Consultee Comments for Planning Application 22/01785/PLF

Proposal: Conversion of existing agricultural building to two dwellings

Name: . Highway Development Management

PROPOSED BLOCK / ROOF PLAN : 1:500

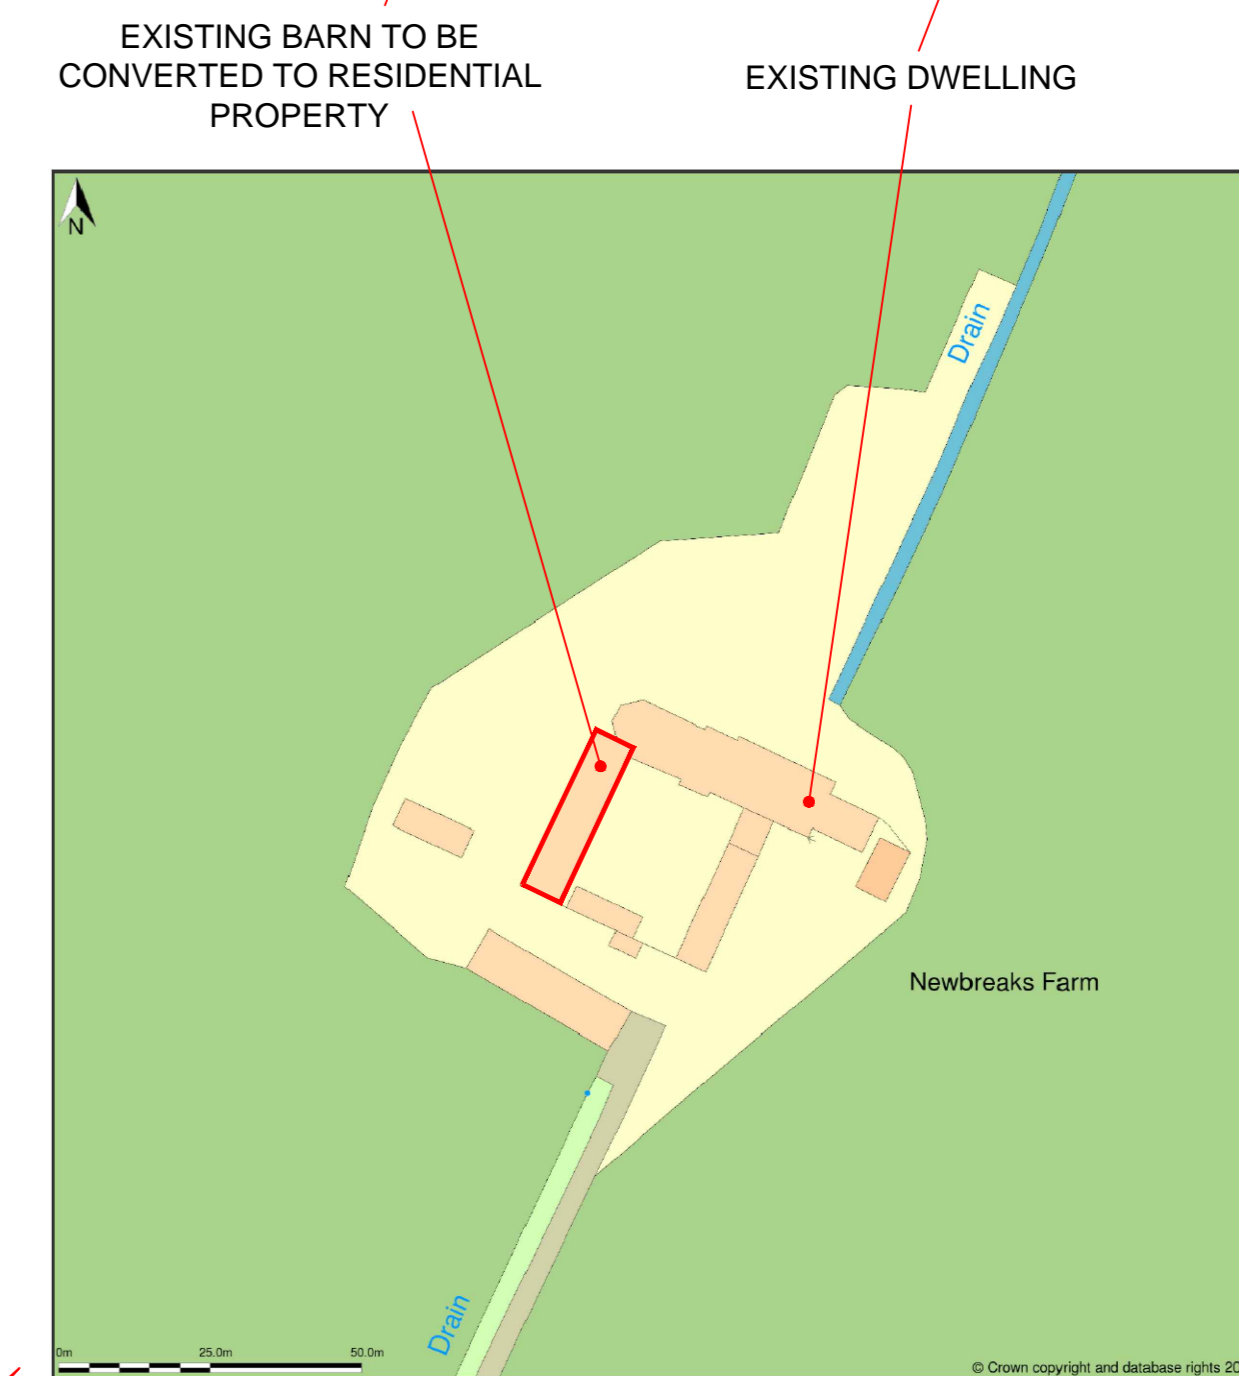
In principle Highway Management has no objection to the proposed development, however the site access is not clearly shown on any of the proposed plans. The access should measure 5m wide for a minimum distance of 8m when measured from the edge of the carriageway in order to facilitate two way movement at the site access and to allow vehicles to pull into the site and prevent stopping and waiting on the public highway which could be hazardous to highway safety. The access will also need to be surfaced and constructed to ERYC Streetscene Services specification in order to prevent gravel and debris from being dragged onto the public highway which is an offence under the Highways Act 1980 (sections 148, 149 and 161). Annotated amended plans are required to show these changes in order to gain support from Highway Management.

Highway Management suggest that further information is submitted before a recommendation is made.
